Phone: 07847 200073
Email: Lancashire.Archaeology@Gmail.Com
Your ref: 3/2017/0012
Date: 7th February 2017

**Planning Application 3/2017/0012: Higher Boyce Farm, Stoneygate Lane,
Ribchester PR3 3YN; Conversion of agricultural building into two dwellings.
Resubmission of planning application 3/2016/0177**

Drawing Title
Proposed Plans and Elevations

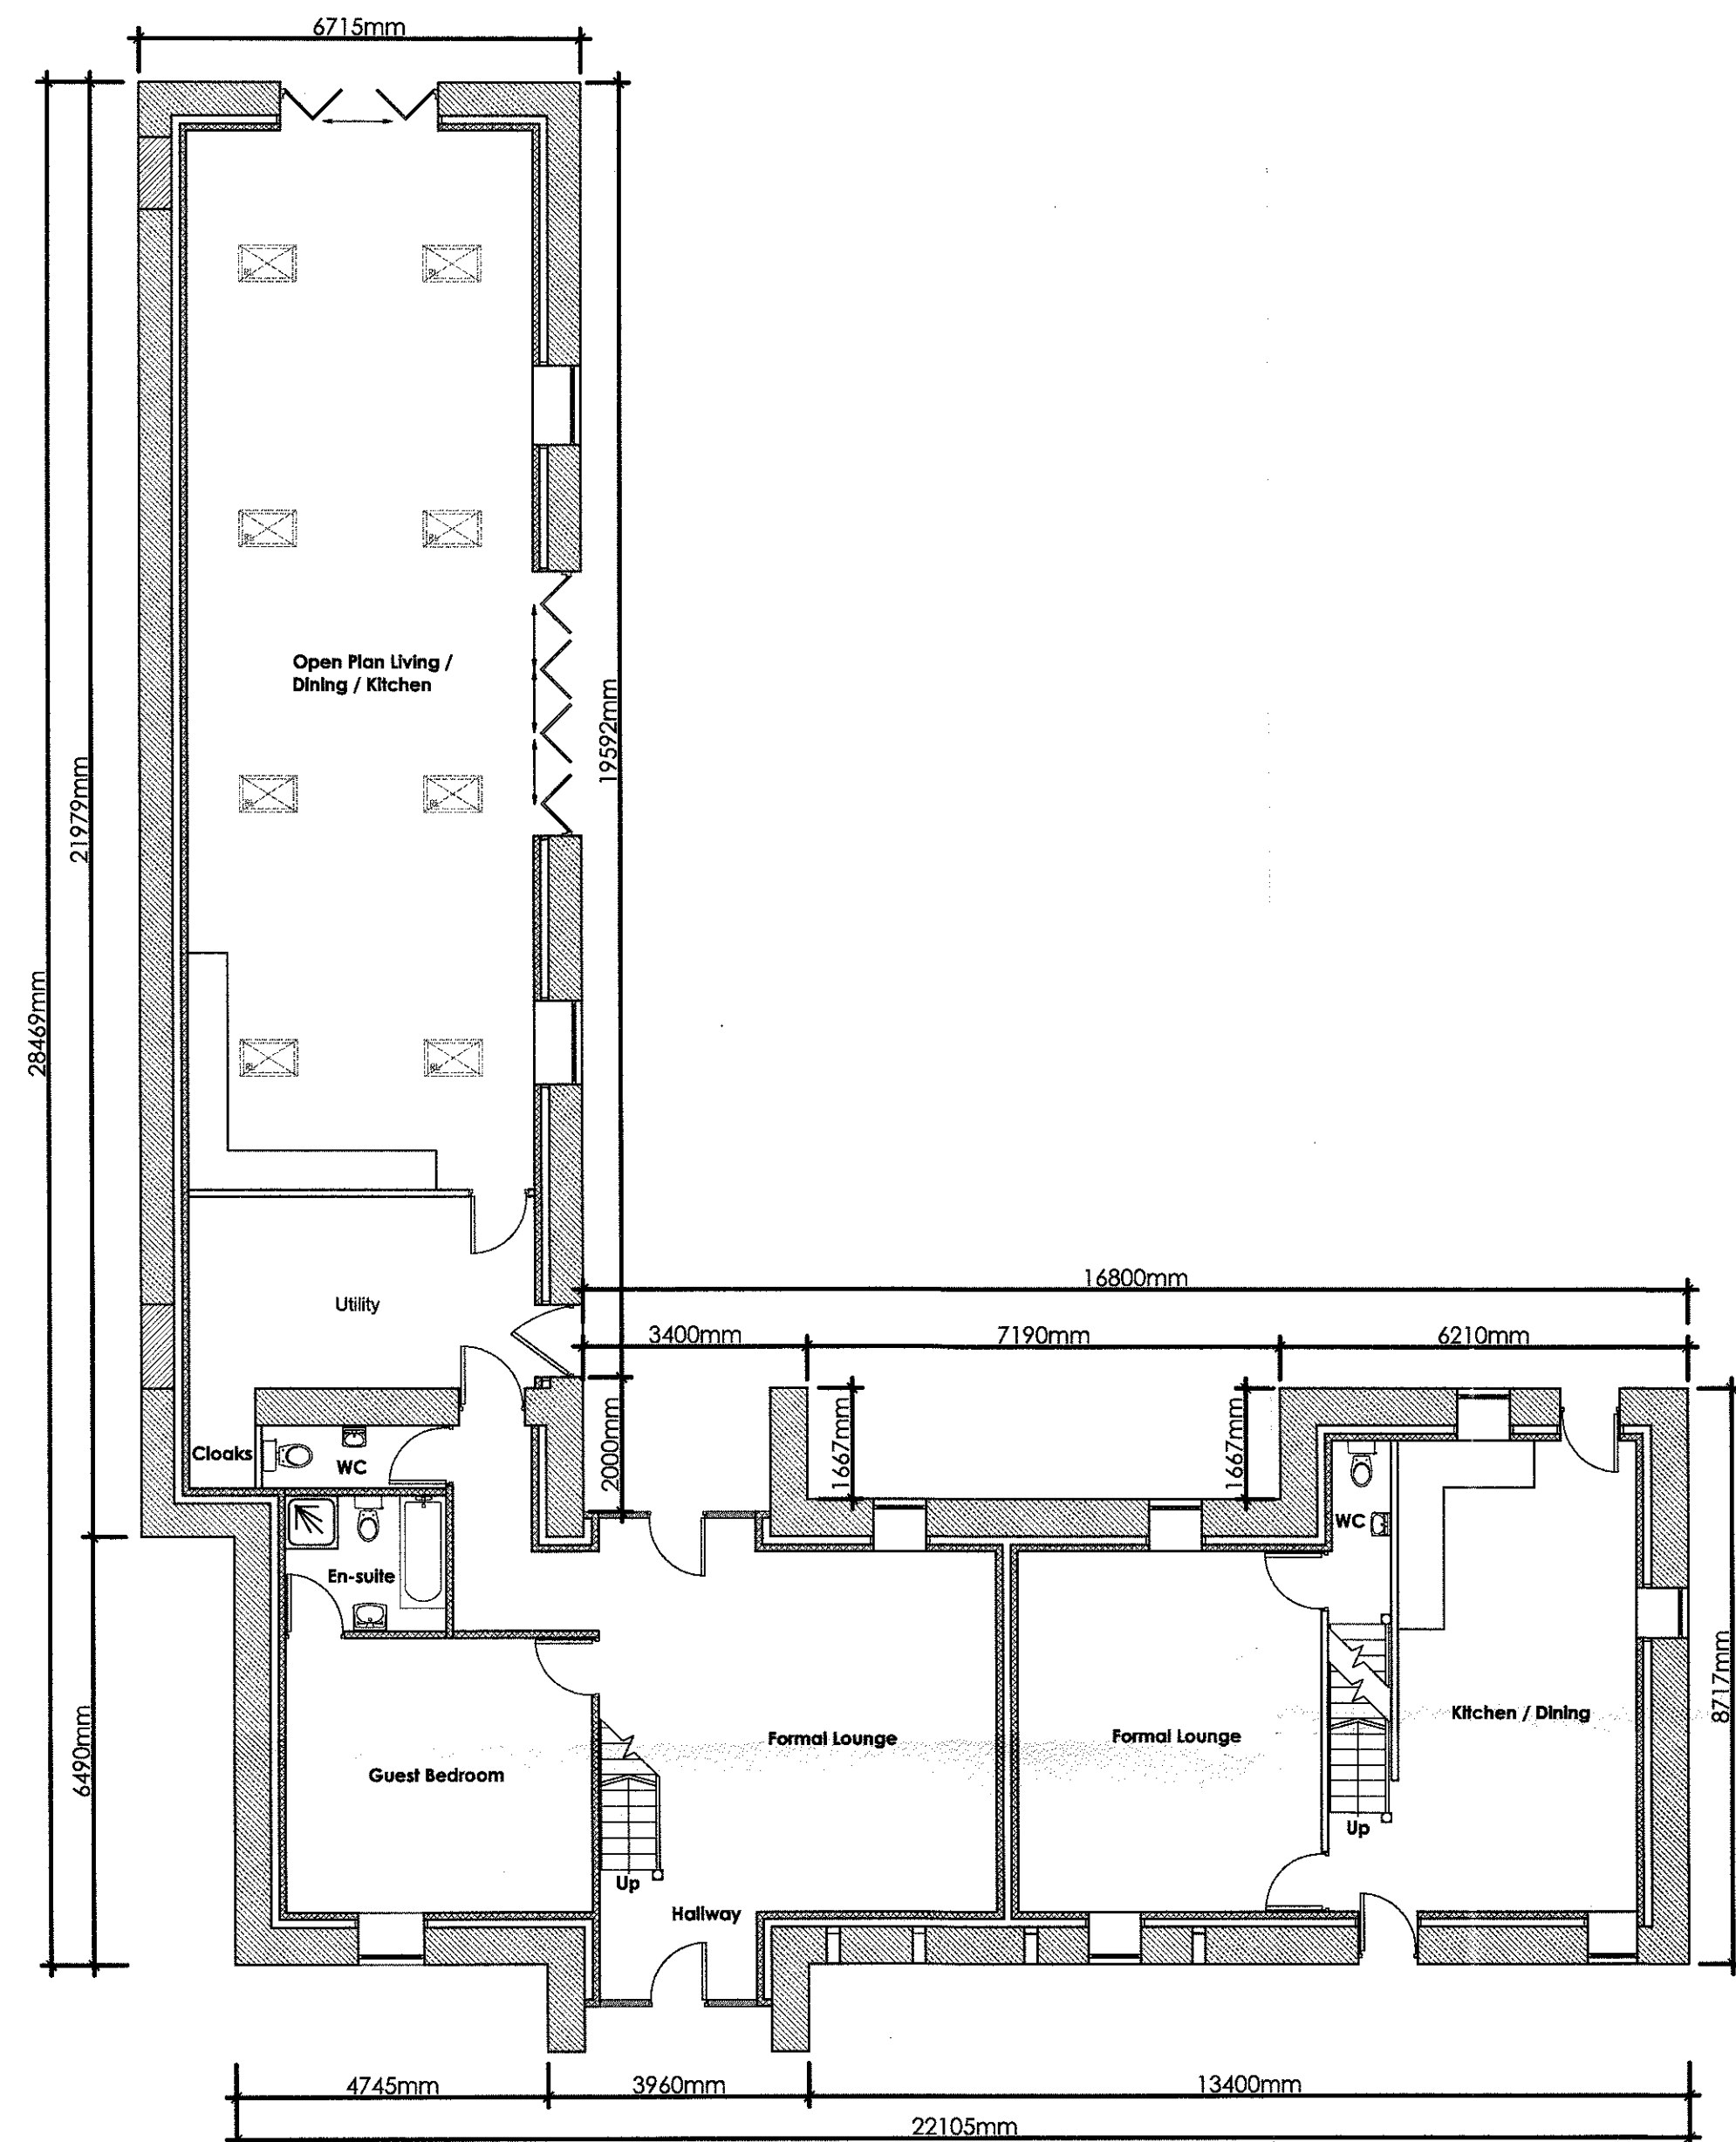
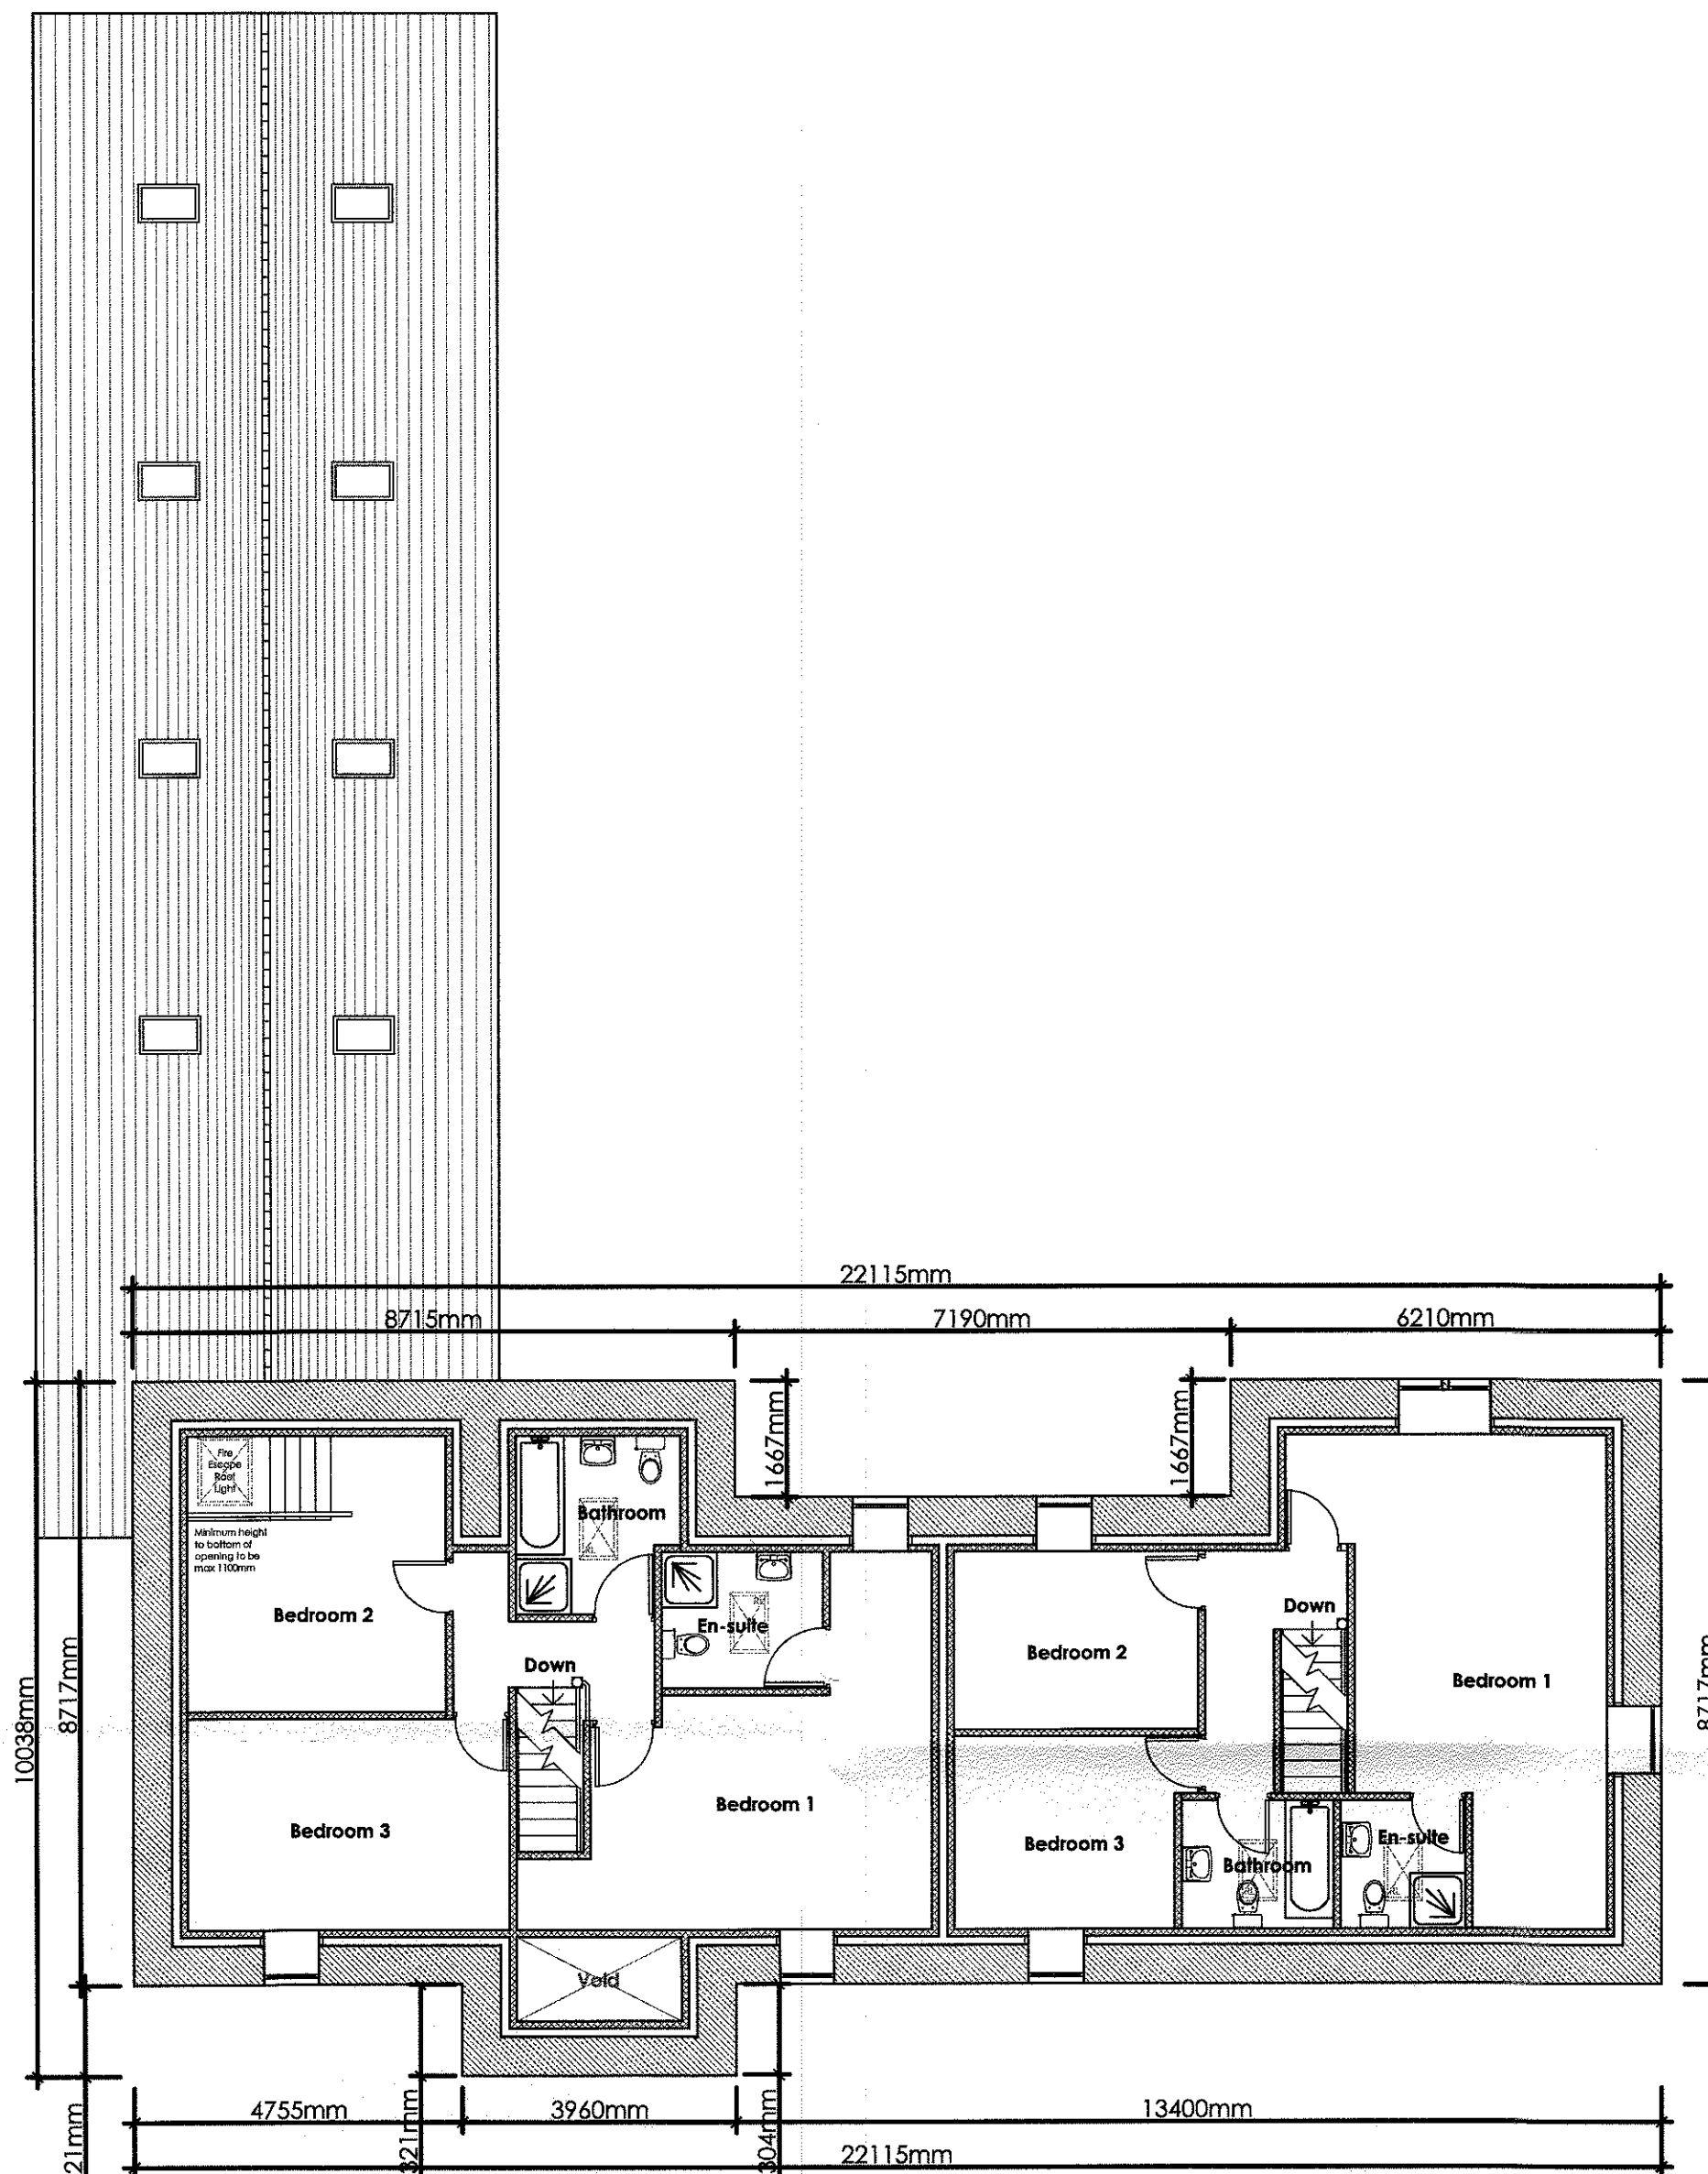
The building proposed for conversion appears on the OS 1:10,560 mapping of 1847 (sheet Lancashire 54, surveyed 1844) and had been extended by 1893 (OS 1:2,500 sheet Lancashire 54.10, surveyed 1892). As such it is considered of some heritage significance as it will retain information relating to earlier farming practices and uses. We would note that there appear to be a large number of new openings proposed in the historic fabric as part of the development and would suggest that consideration be given to reducing these in number and/or size, so as to reduce the impact on the significance of the building.
